Our Ref: TR010056

Application by Highways England for an Order Granting Development Consent for the A417 Missing Link Project

Advice following issue of decision to accept the application for examination

DO NOT SCALE

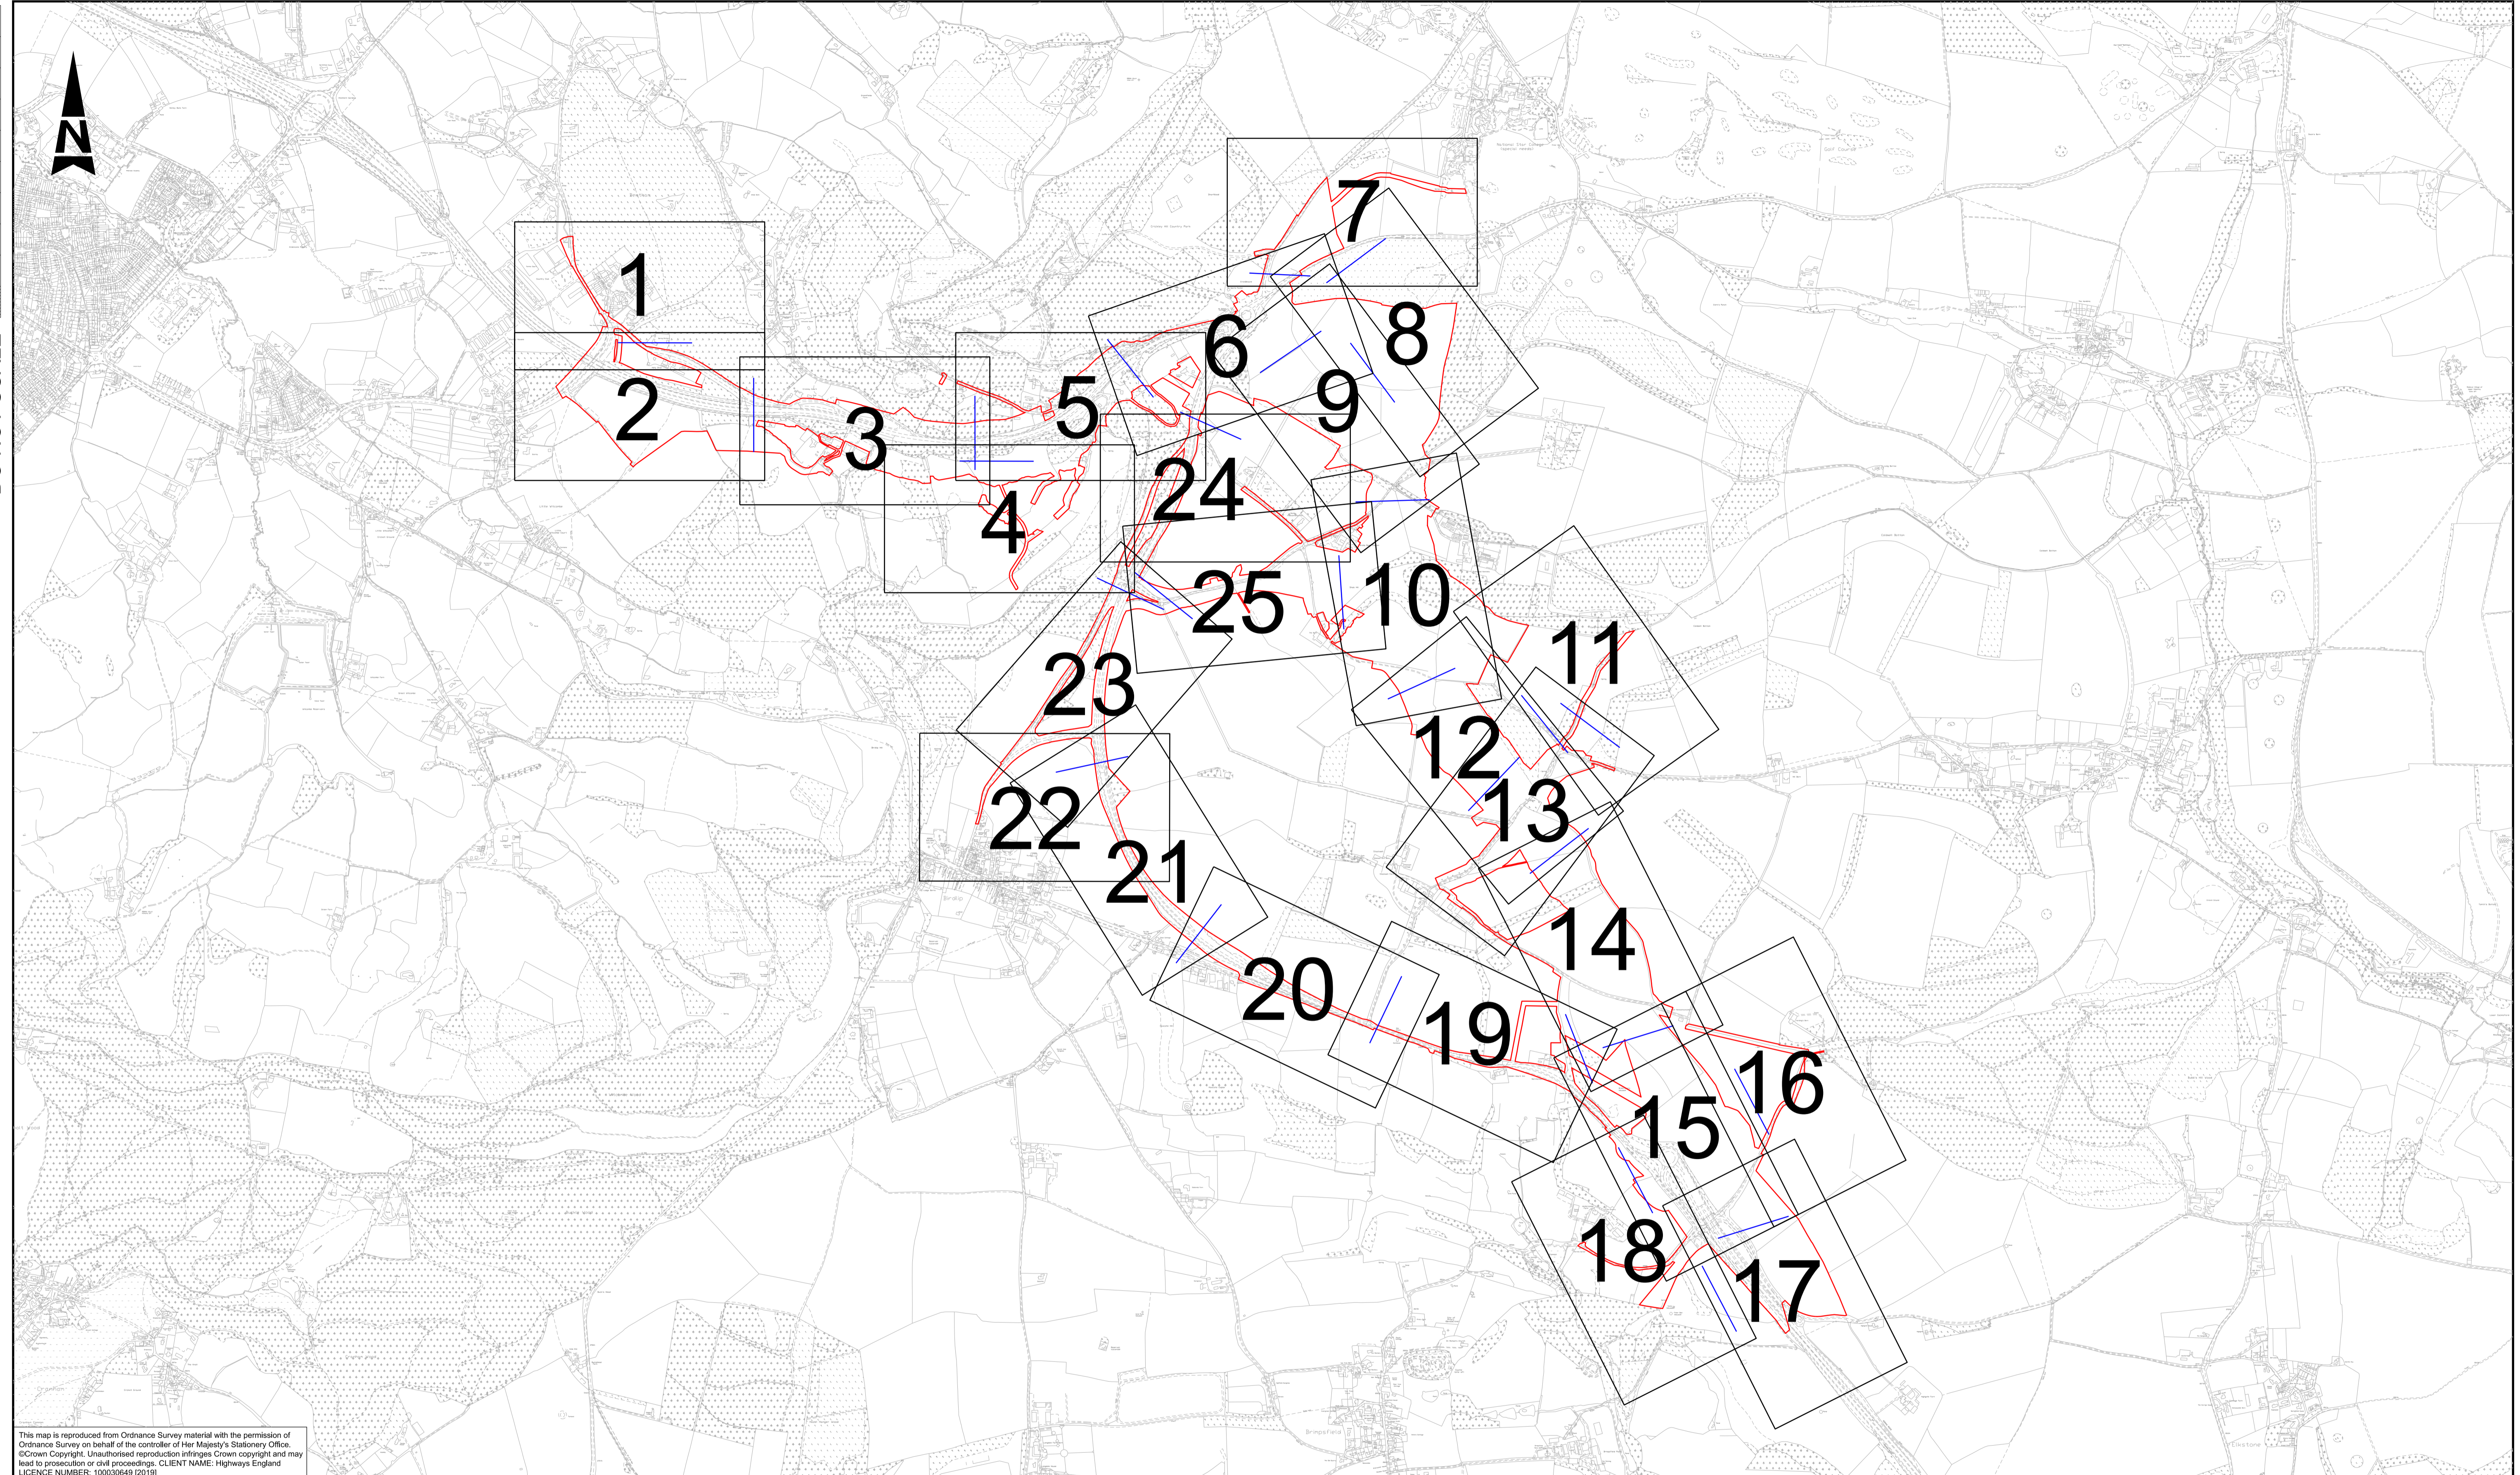
It would assist the future Examination if Sheets 1-6 included further high-level information about the scheme such as shaded areas of environmental mitigation and enhancement, retained woodland etc, as shown on the Environmental Master Plan (Figure 7.11).
